From: Paul Cann
Sent: 16 June 2017 15:15
To: Planning.Responses
Subject: RE: Planning Consultation on: Y/34/17/HH

Engineers comments in respect to surface water drainage:

APPLICATION Y/34/17/HH

Site Address: Forge Cottage Church Road Yapton BN18 0ER

Title			
GROUND FLOOR PLAN AS PROPOSED			
Date	Drawn	Scale	Checked
MAR 17	SR	1:100 @A3	MAW
Job Number	Prefix	Drawing Number	Revision
17004	P	106	C

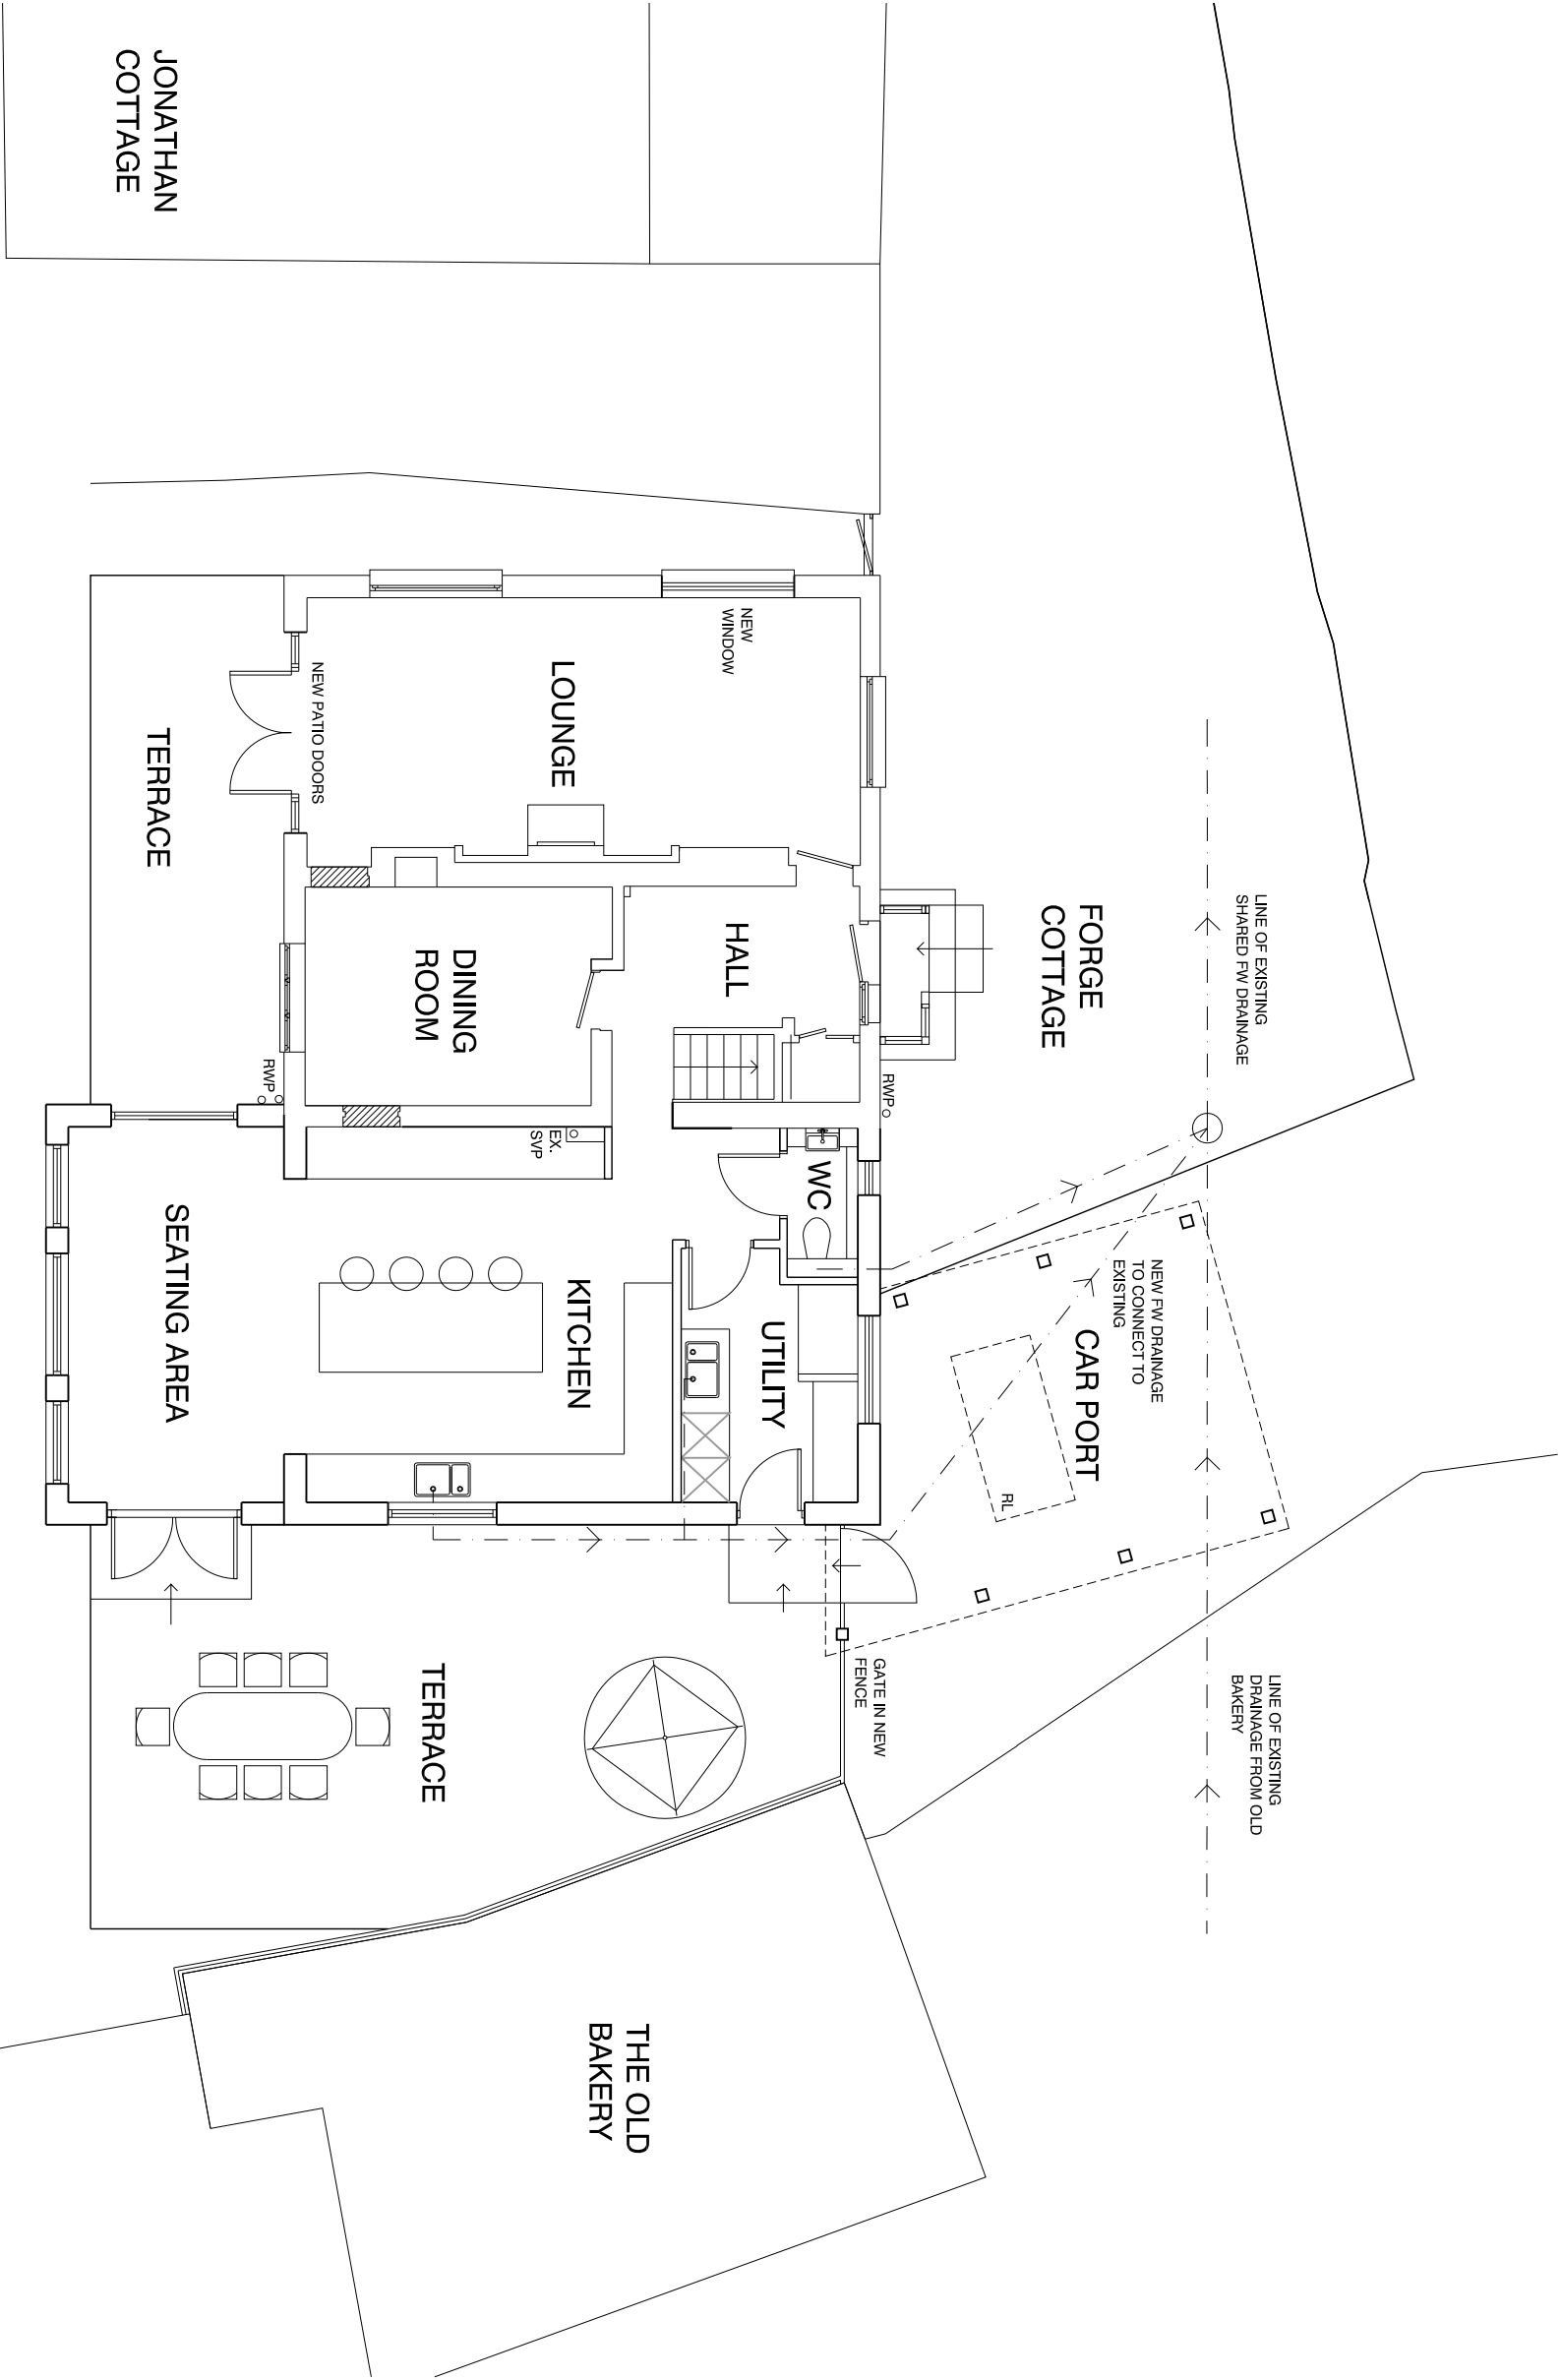
Infiltration must be investigated for surface water disposal.

Please apply standard condition ENGD2A.

Infiltration rates for soakage structures are to be based on percolation tests undertaken in the winter period and at the location and depth of the proposed structures. The percolation tests must be carried out in accordance with BRE 365, CIRIA R156 or a similar approved method and cater for the 1 in 10 year storm between the invert of the entry pipe to the soakaway, and the base of the structure. It must also have provision to ensure that there is capacity in the system to contain below ground level the 1 in 100 year event plus 30% on stored volumes, as an allowance for climate change. Adequate freeboard must be provided between the base of the soakaway structure and the highest recorded annual groundwater level identified in that location.

Any SuDS or soakaway design must include adequate groundwater monitoring data to determine the highest winter groundwater table in support of the design. The applicant is advised to discuss the extent of groundwater monitoring with the Council's Engineers. Supplementary guidance notes are also enclosed for information.
